242-244 Beecroft Road, Epping (SSD-8784)
Request for Additional Information

I refer to the redevelopment of 242-244 Beecroft Road, Epping (SSD-8784). After considering your Response to Submissions (RTS) and the agency responses to the RTS, the Department requests that you provide the following additional information:

DRAWING TITLE	CONCEPT PROPOSAL SECTION 1
SCALE:	1:500 @A3
DRAWING NUMBER	13
PROJECT NORTH	PROJECT NORTH
REVISION	3

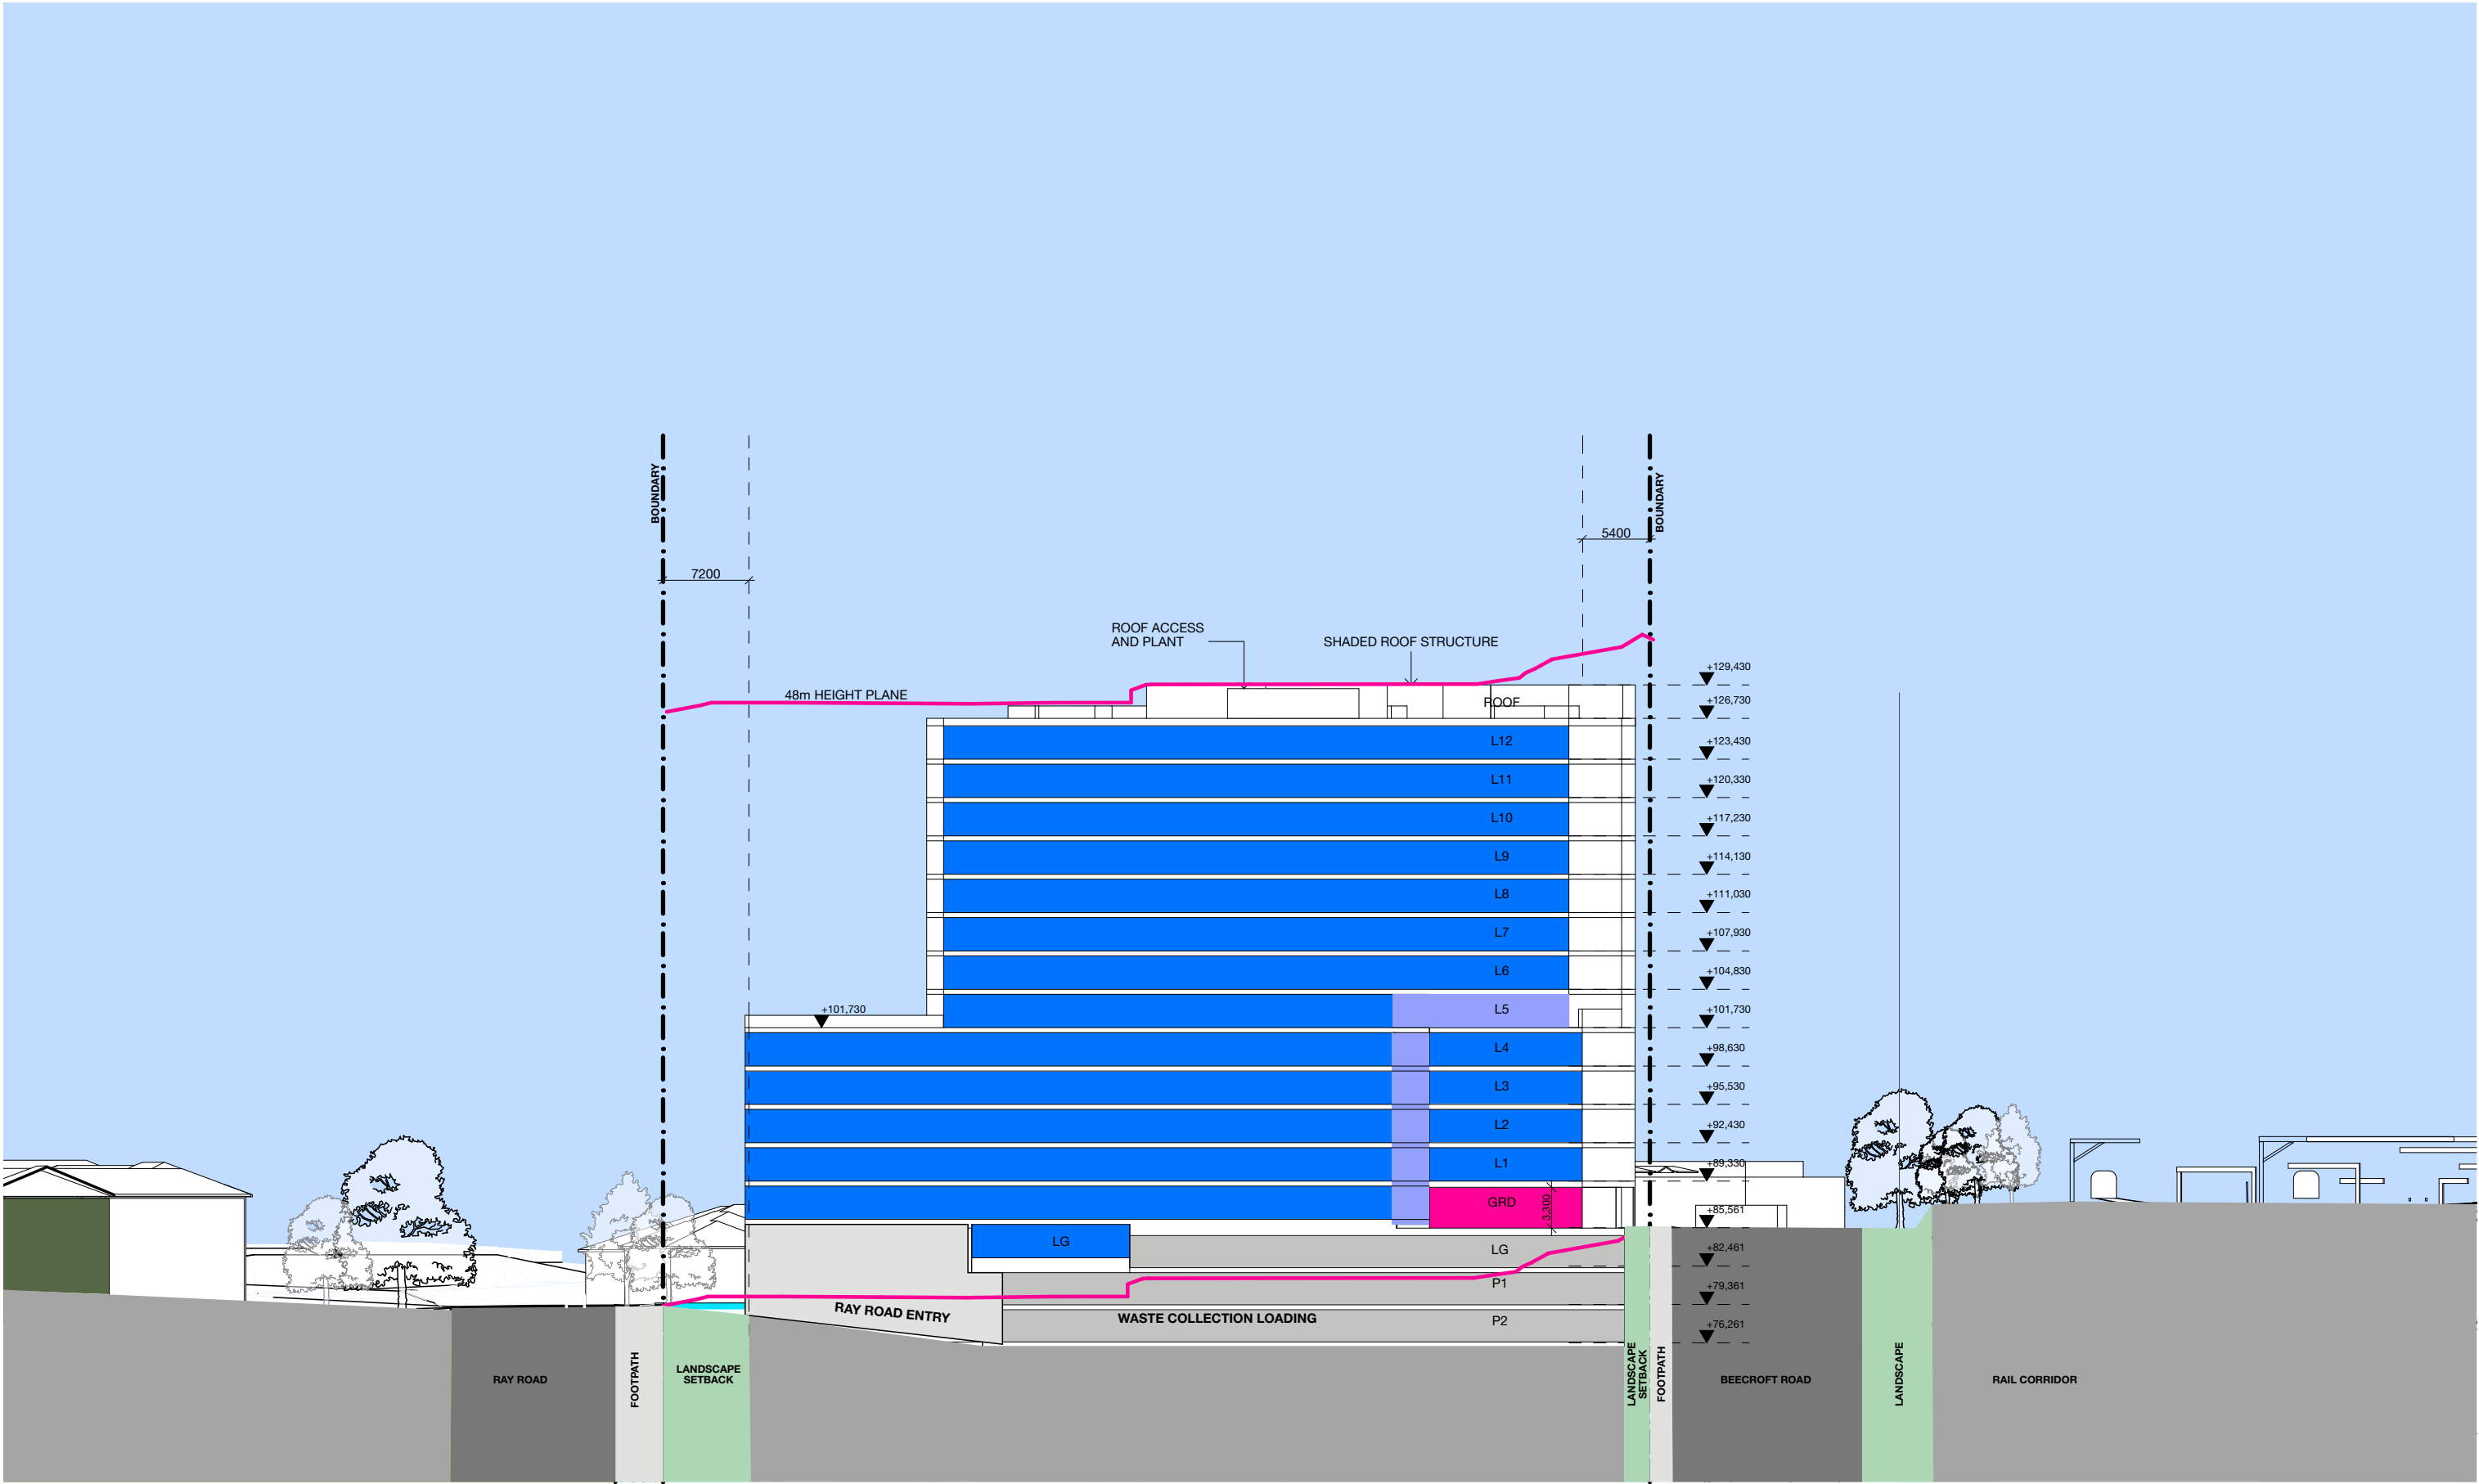
- Amend Section 1 within the Design Drawings to accurately show the proposed Beecroft Road setback without trees.
- Amend Envelope View 1 within the Design Report to accurately show the treatment of the Beecroft Road setback, containing footpaths and a hard courtyard in lieu of tree planting shown.
- Please provide high-quality photomontages or perspectives of the proposal that are suitable for use with the Department's Assessment Report and website. For instance, provide an updated perspective of the previous image of the internal courtyard and adjacent indicative buildings.

**Through Site Link**

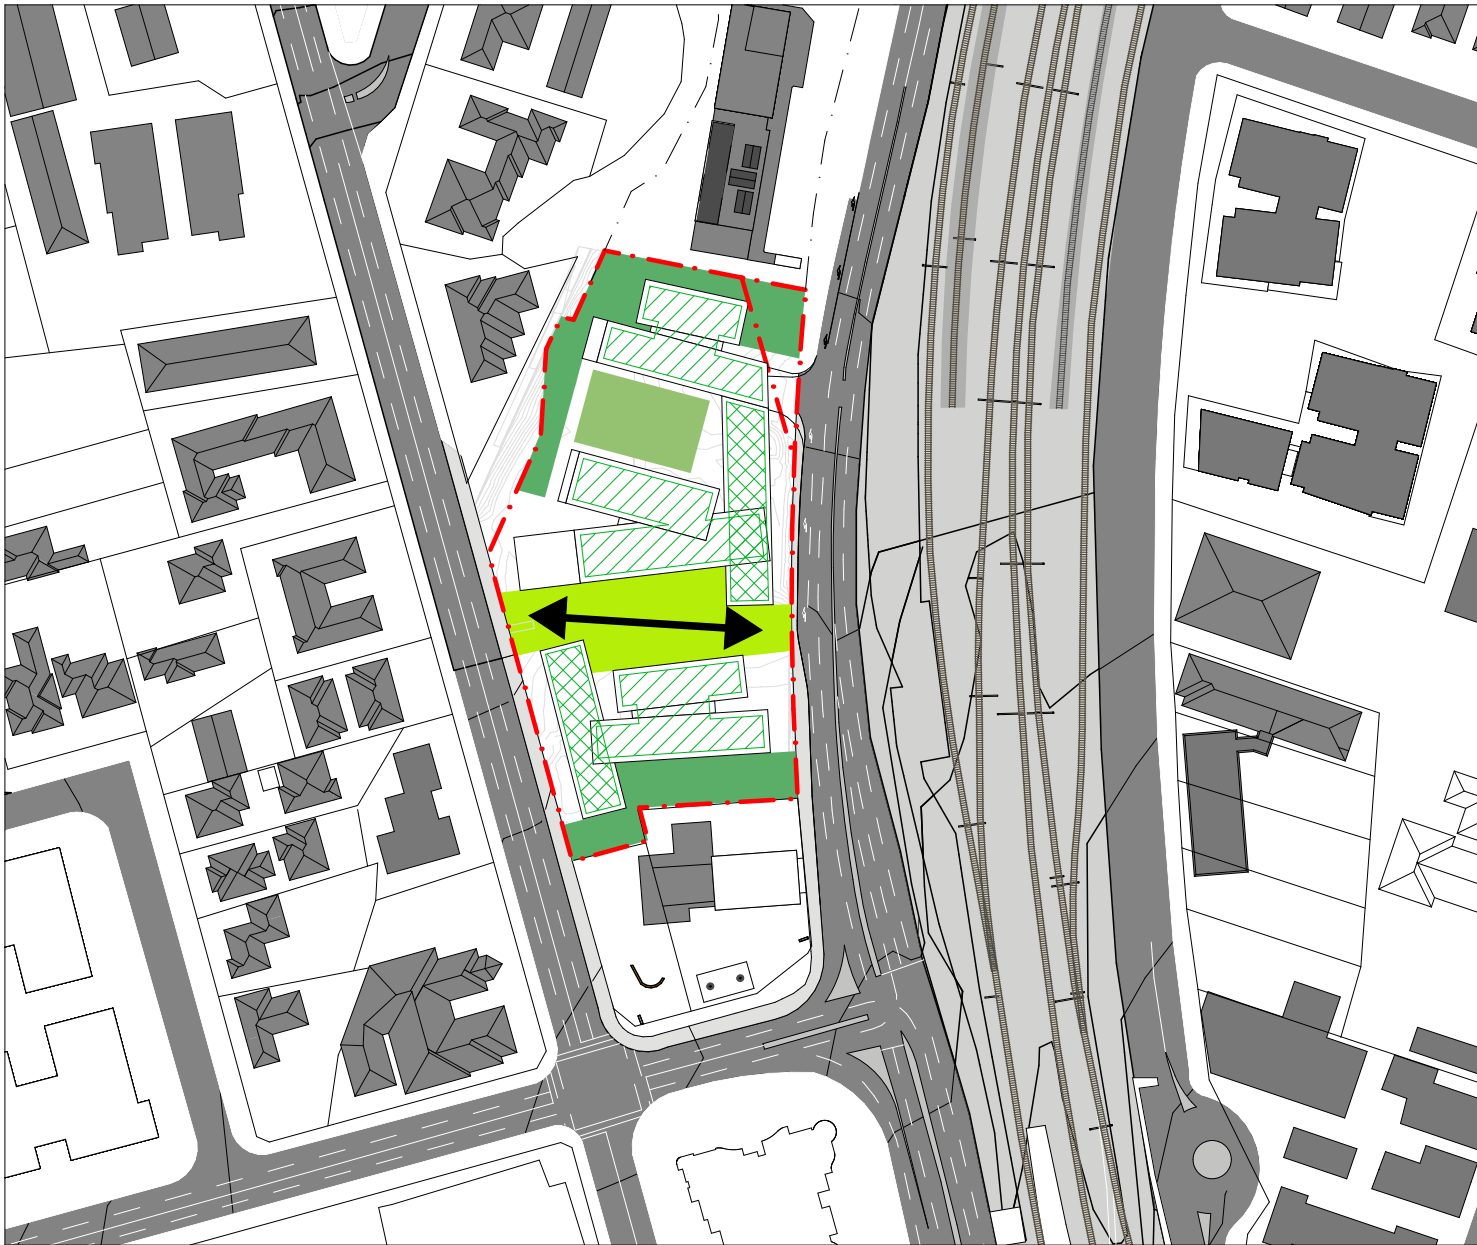
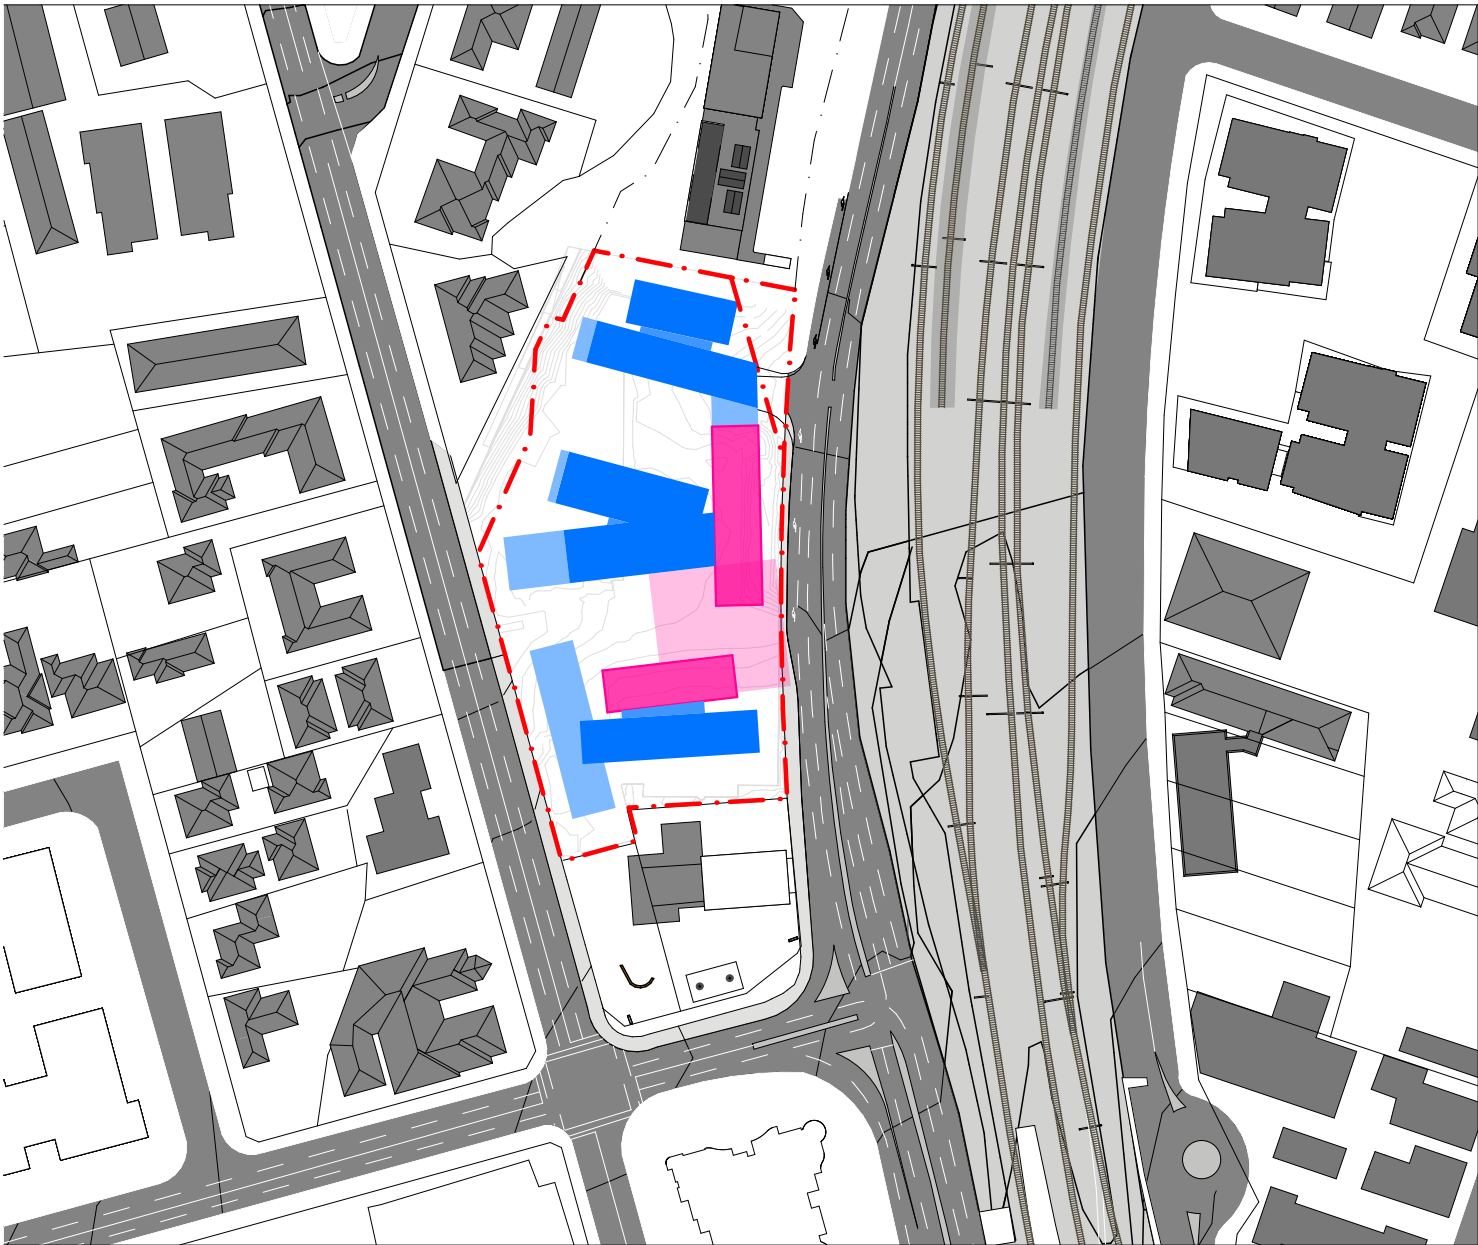
- Provide additional design guidance for landscaping and open space in relation to:-
 - treatment of basement protrusions and aboveground car parking
 - building identity and the provision of high quality pedestrian access to residential lobbies
 - the pedestrian through-site link in terms of its public and private purposes, accessibility, visual connectivity and passive surveillance.
- Clarify the through-site link design capacity and consider safety for cyclists.

- Consider providing additional deep soil zones within the widened pedestrian through-site link to provide improved amenity and visual privacy for residential uses.
